Consultee Comments for Application 2025/91579

Application number: 2025/91579

Location: The Homestead, Hurst Knowle, Almondbury, Huddersfield, HD5 8SG

Proposal: Demolition of the former Homestead care home and erection of 28 dwellings, comprising 20 apartments and 8 bungalows, with access from Hurst Knowle and associated external works including landscaping

FRONT
1 : 50

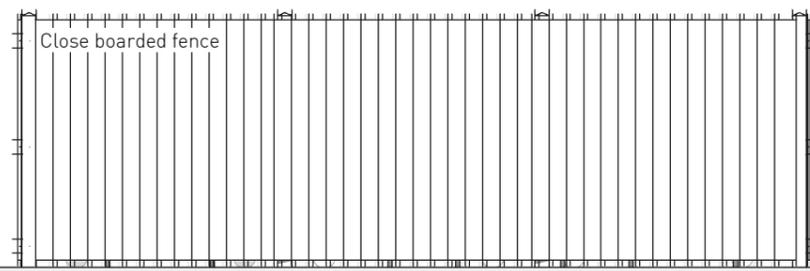
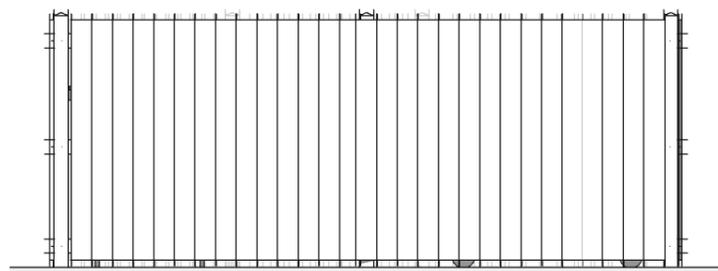
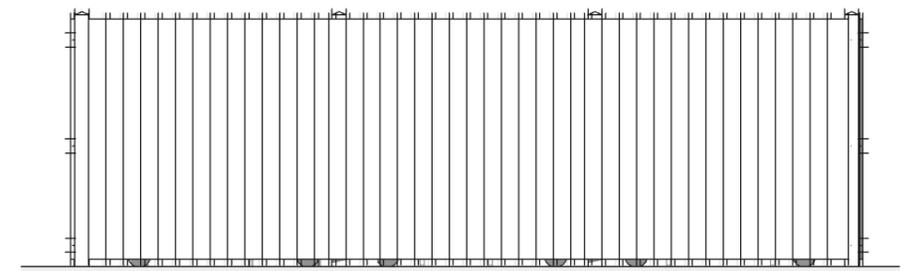
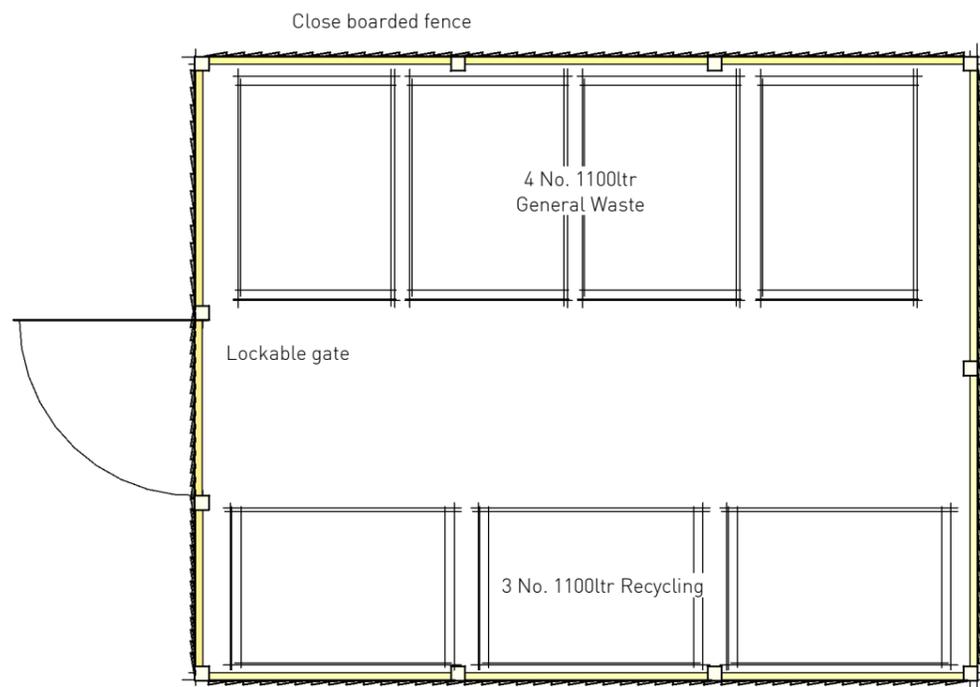
barriers by using walls or fencing to a minimum height of 1.8m. There may be circumstances where more open fencing is required to allow for greater surveillance.

Sub-divisional boundaries are also required to be 1.8m high to achieve security, demarcation and privacy. Again, trellis topping can be utilised here (1.5m solid fence + 30cm of trellis topping).

Gates to the side of dwellings that provide access to rear gardens or yards must be robustly constructed, be the same height as the fence (minimum height 1.8m) and capable of being locked (operable by key from both sides of the gate). The gates must not be easy to climb over, crawl under or removed from their hinges.

Fencing and gates shall be at least 1.8m in height and certified to one of the following minimum standards or above:
